**From:** Tim Townsend [REDACTED]  
**Sent:** 16 September 2015 10:59  
**To:** caroline.gould  
**Cc:** Neil Crowther; Harvey Rogers; Paul Davis; Adrian Barnley; Barry Smith  
**Subject:** RE: LU/114/15/RES - Approval of reserved matters following outline planning consent LU/47/11 for layout, appearance and landscaping of access road.

**Subject:** LU/114/15/RES - Approval of reserved matters following outline planning consent LU/47/11 for layout, appearance and landscaping of access road.

Drawing No. CV/8140927/600-1 Rev P7

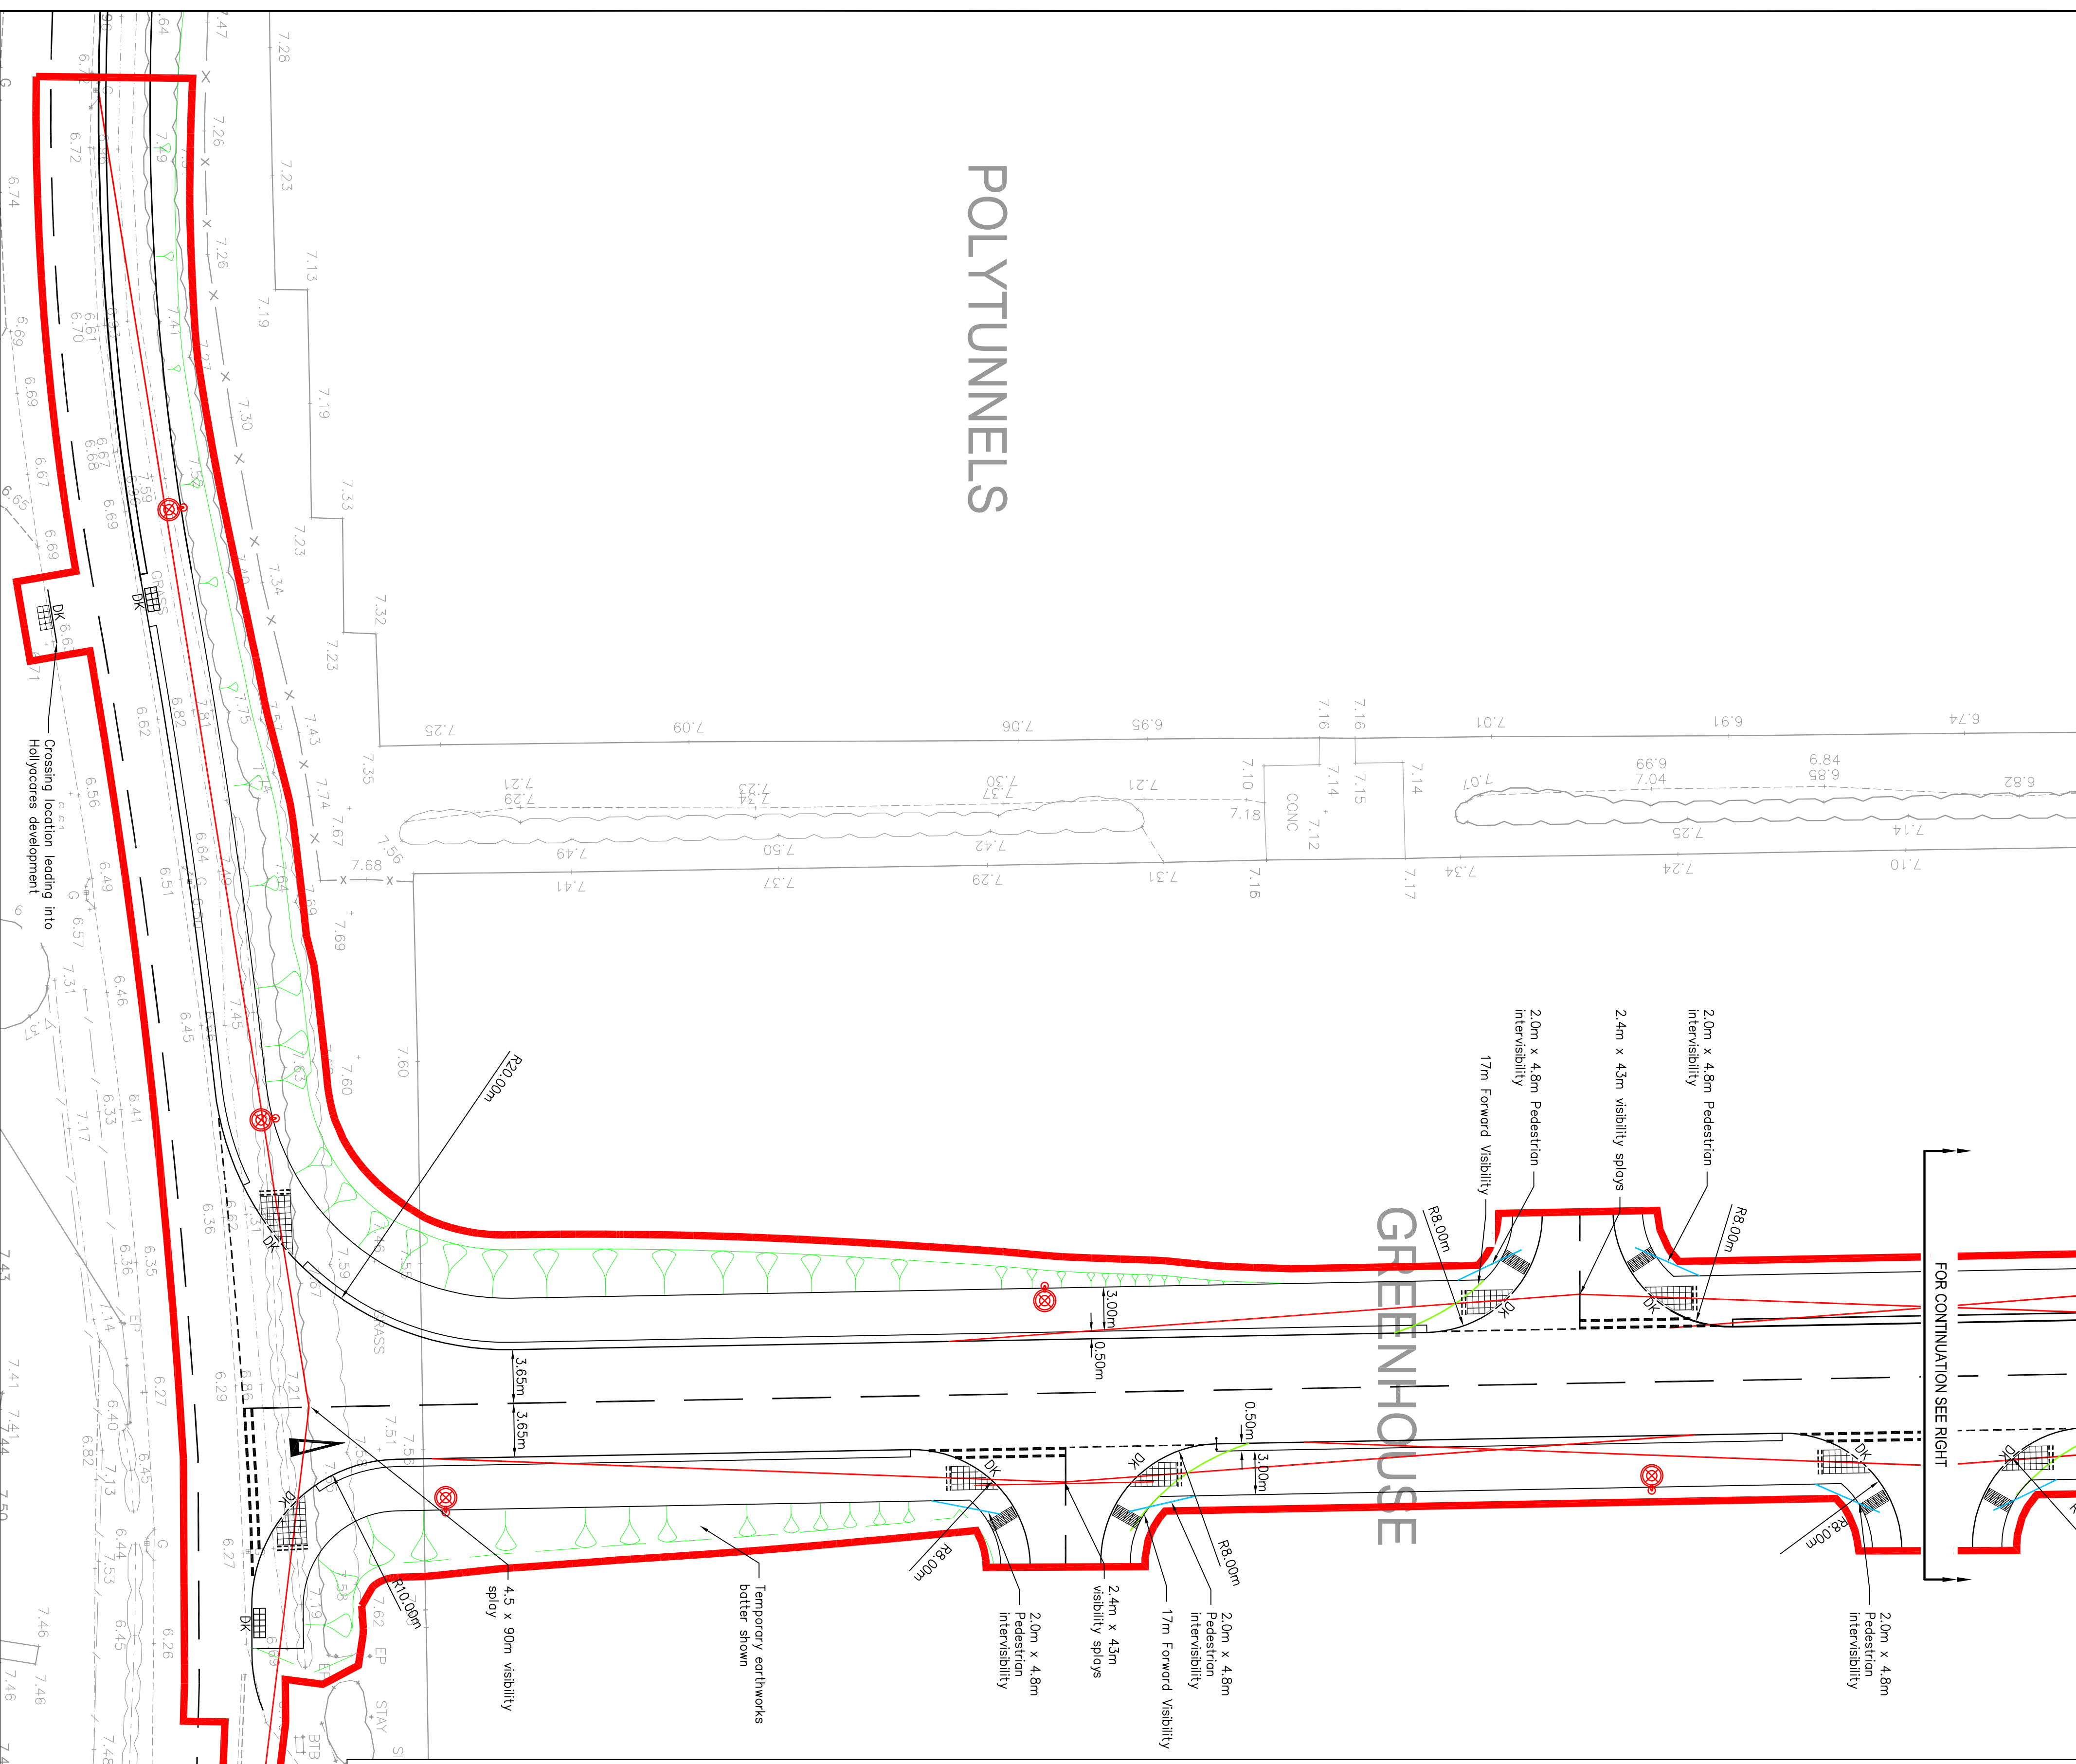
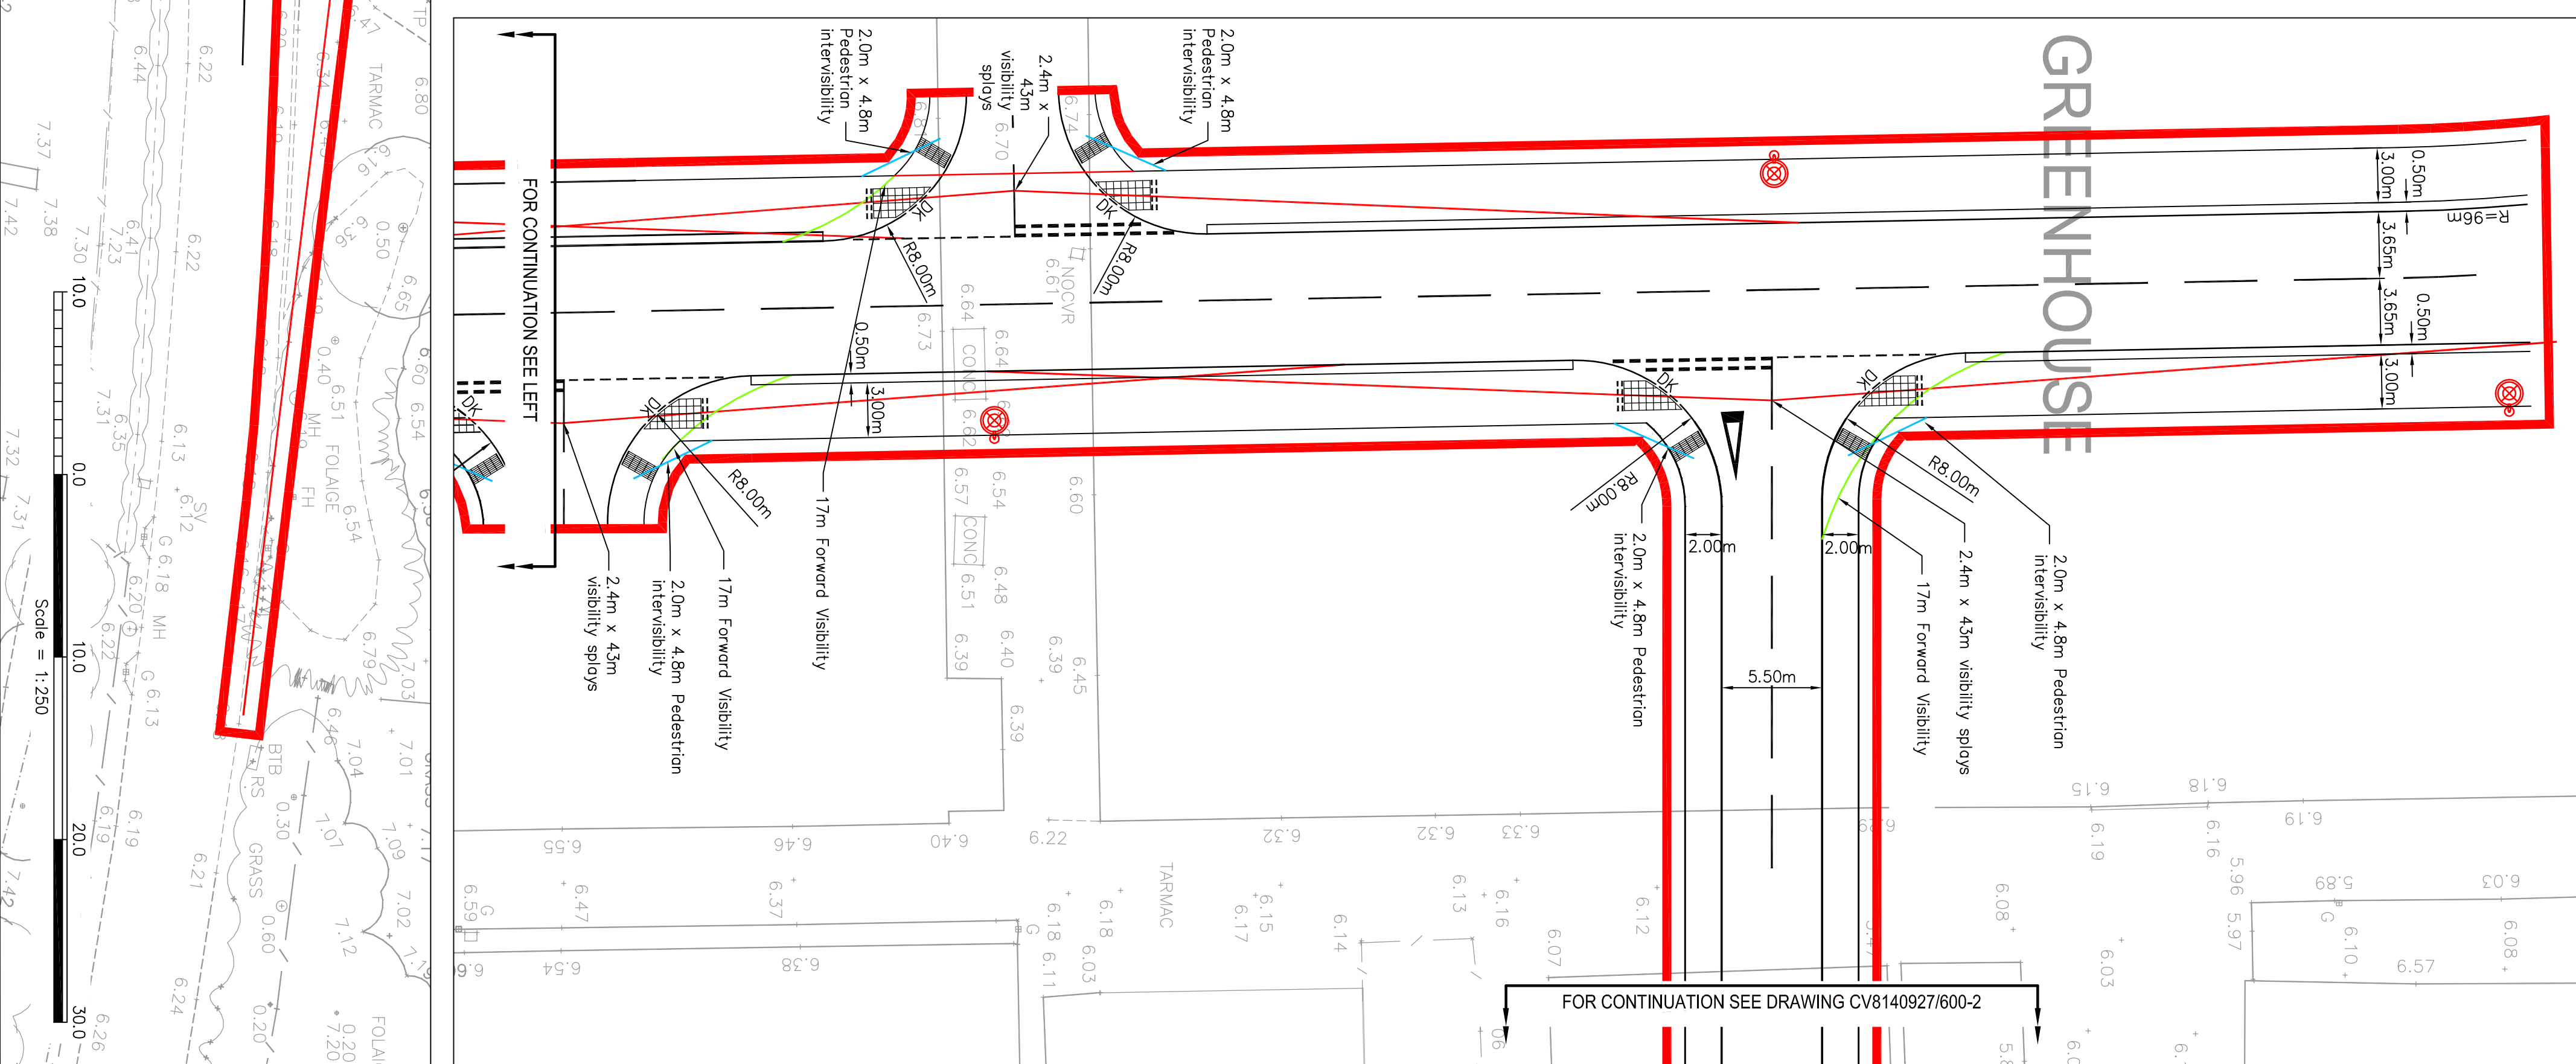
3. Visibility splay, southern end of proposed road junction with Toddington Lane – I do still need to see this, please. It is fundamental to the scheme. You must demonstrate that the sightline splay crosses land in your control (or is over highways land).

4. Cycle/ped intervisibility – 'Cycling England' gives guidance about visibility splays based on stopping sight distances. Section 'B.04 Junction and Forward Visibility' should assist your designers. The 2m x 2m shown on your current version plan is often used for driveways emerging to footways. It is not suitable for the cycle-pedestrian scenario presented here. You will need to interpret the data and demonstrate why any figure chosen is appropriate. Please would you show dimensions at each junction on an amended drawing.
